**Consultation Response from KC,  
 Trees**
**2021/90377 100, Lower Town End Road, Wooldale, Holmfirth, HD9 1QD**
**Erection of two storey rear extension, single storey side extension and exterior alterations**
**Date Responded: 08/03/21 | Responding Officer: Nick Goddard | Responding Ref: CA26**

DRAWING TITLE  
**PROPOSED GROUND FLOOR PLAN,  
FIRST FLOOR PLAN & ROOF PLAN**

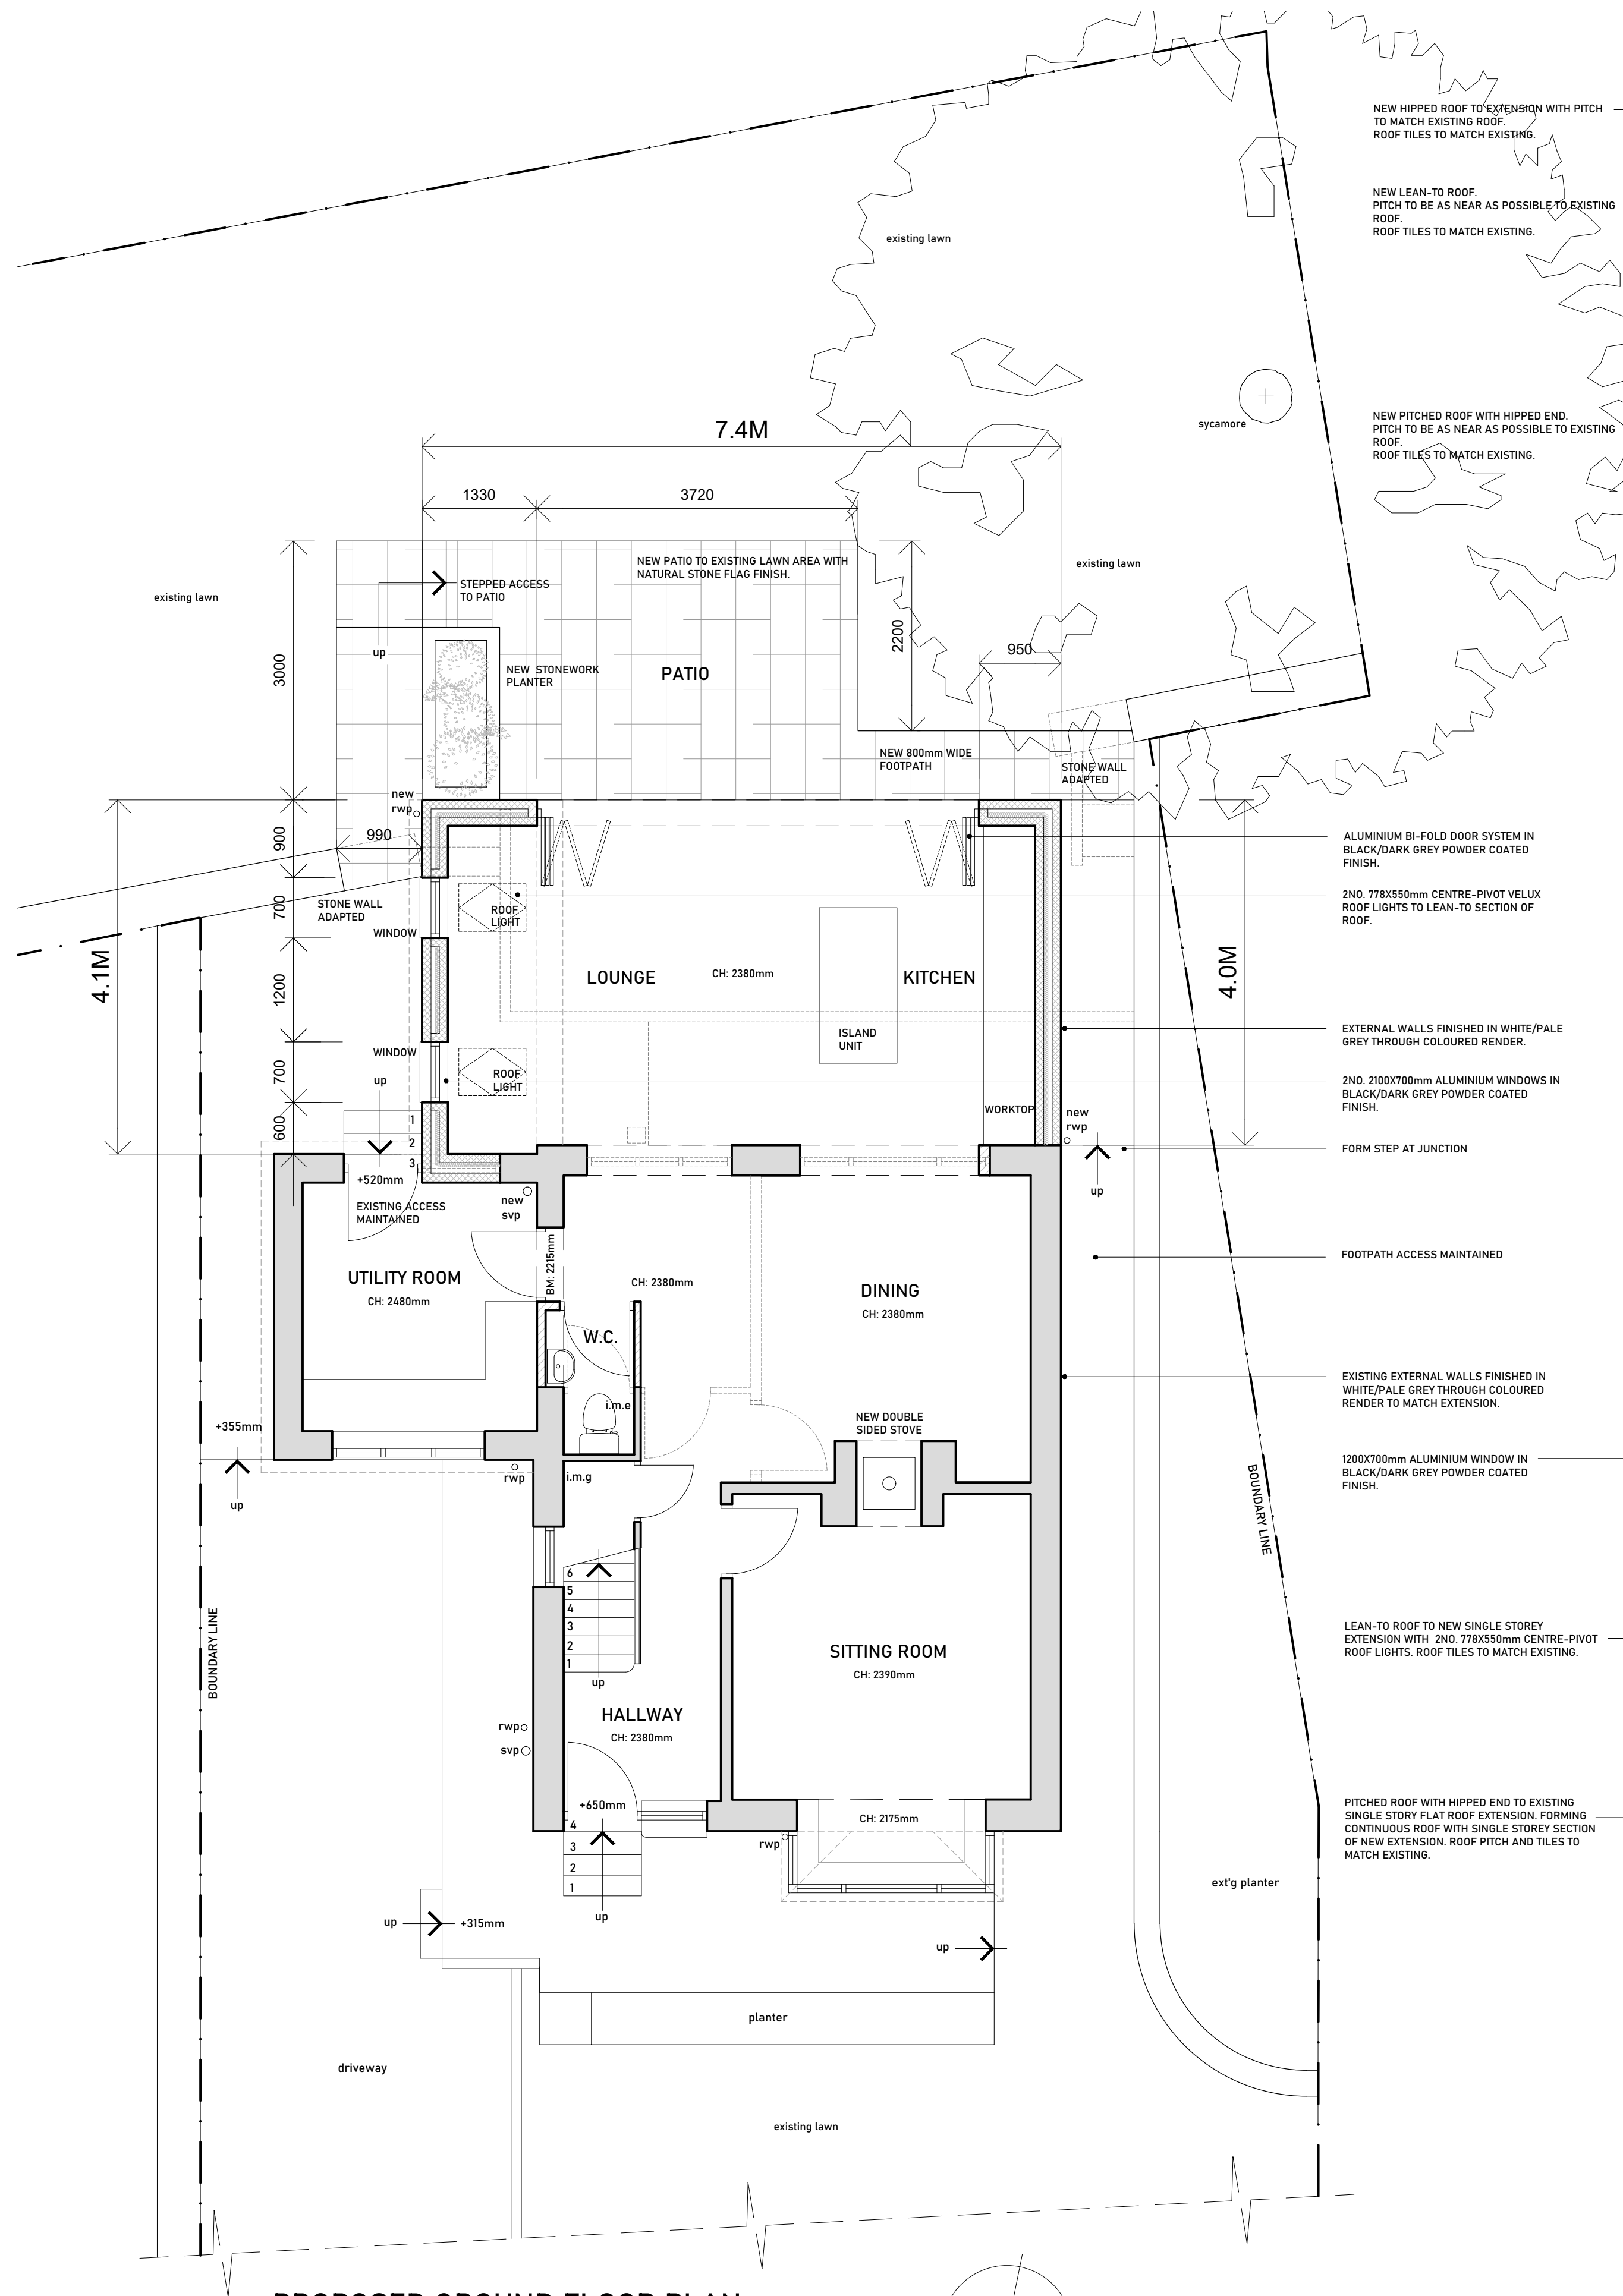
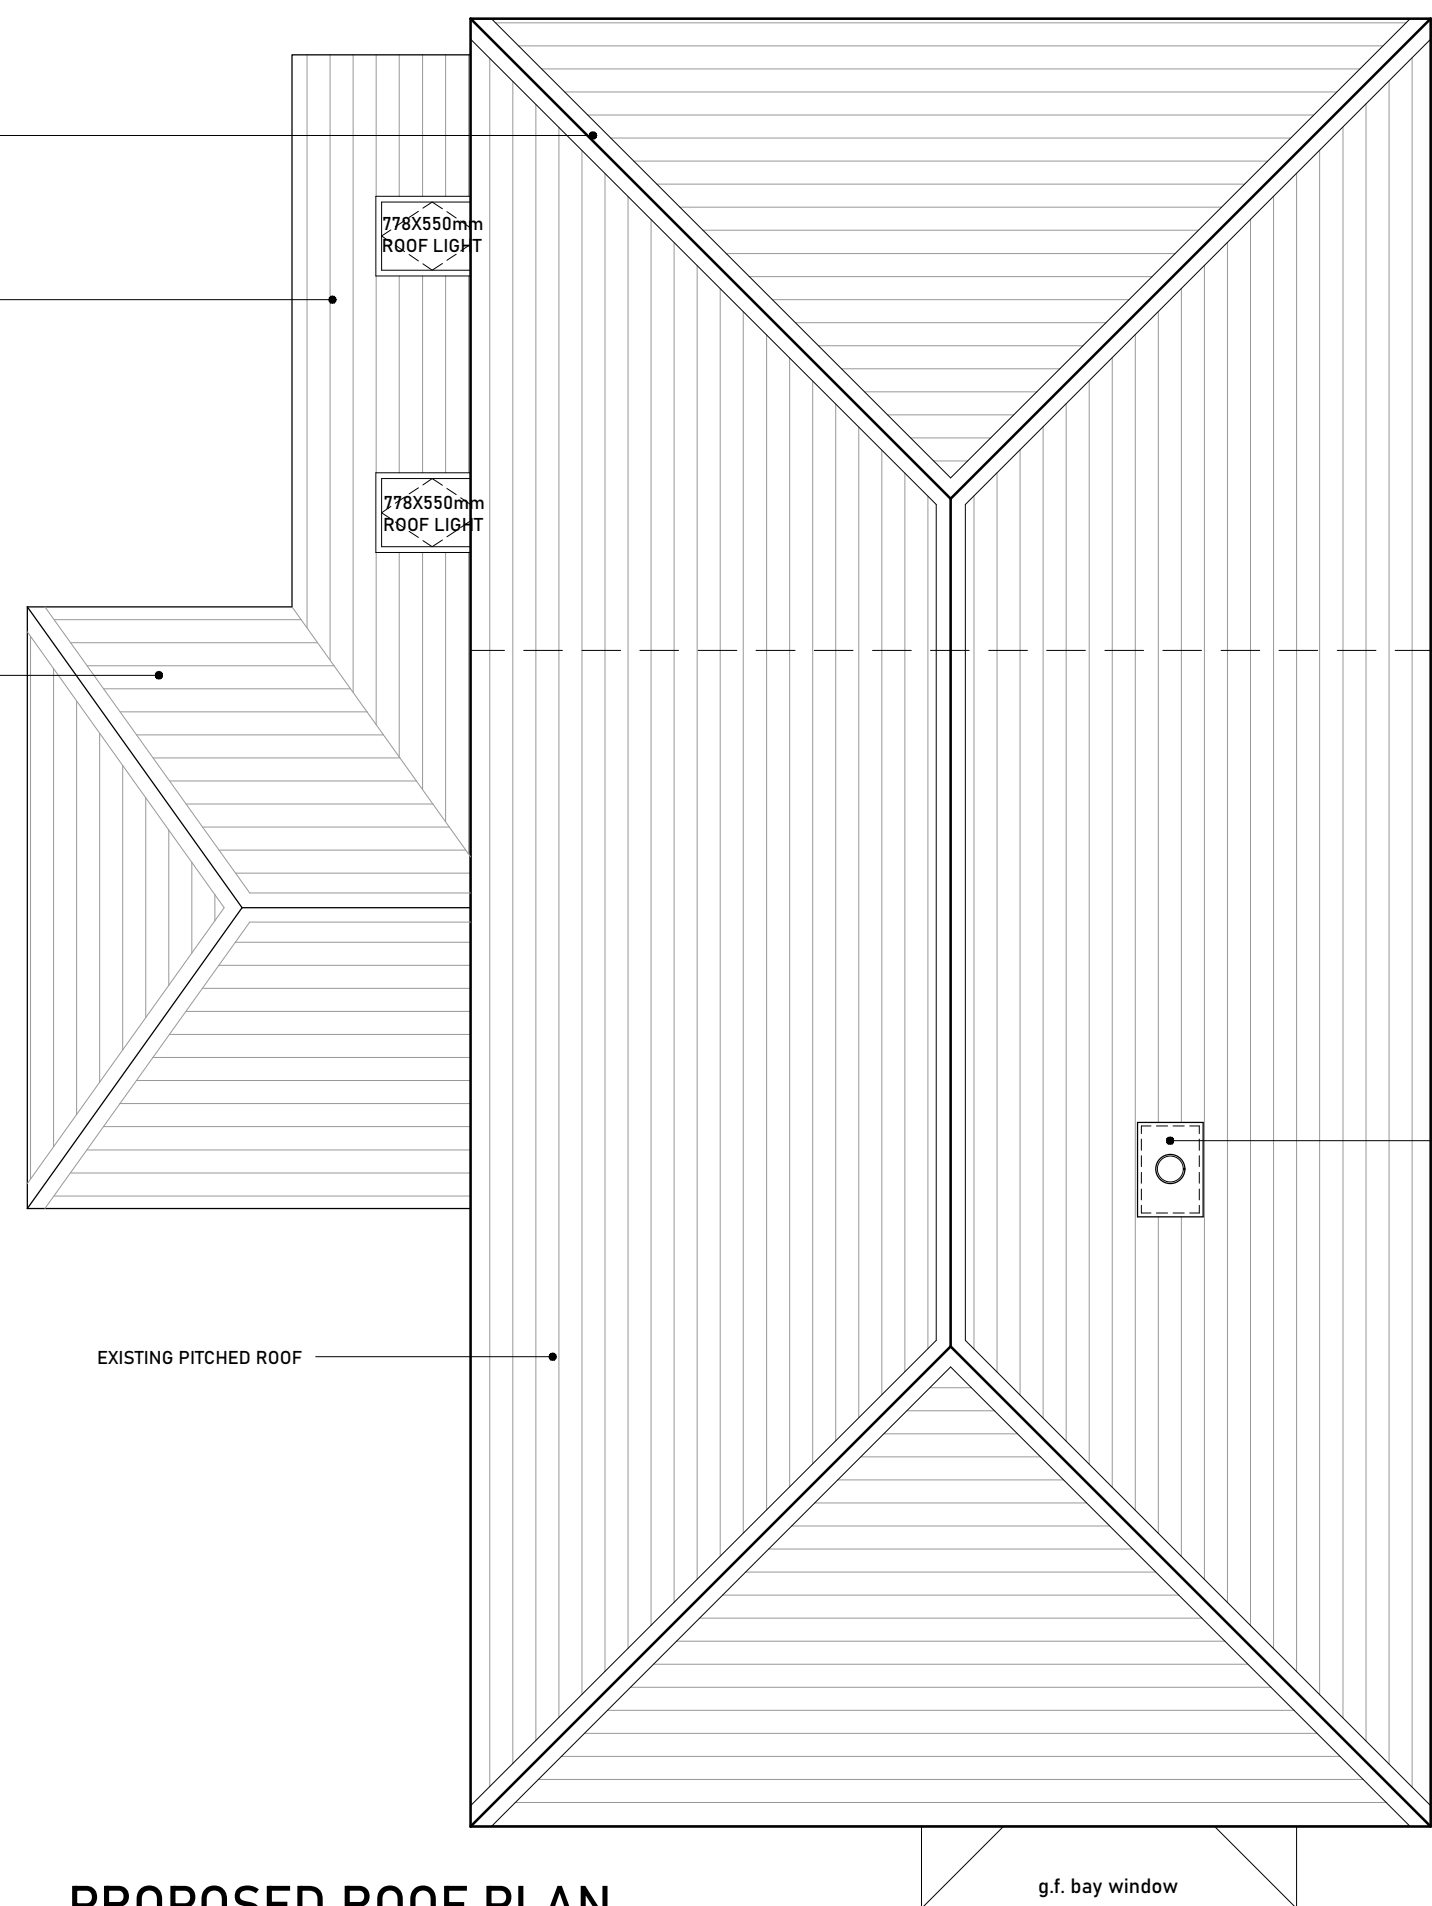
The trees on the site do not appear on any of the submitted information for this application and therefore it is not possible to fully assess the impacts they may have on the proposed extension to the rear. The proposals should have been informed and supported by a tree survey showing the extent of canopy spread, and root protection area of the trees. An impact assessment could then be made as to which trees are required to be removed and what measures are needed to retain the good quality tree on site.

At present I have concerns that the foundations for the extension may impact upon the roots of the tree; the second storey may be close to the canopy of the tree; and the proposals include a stone planter in the location of the tree which could impact upon the roots if it raises soil levels around the base of the tree.
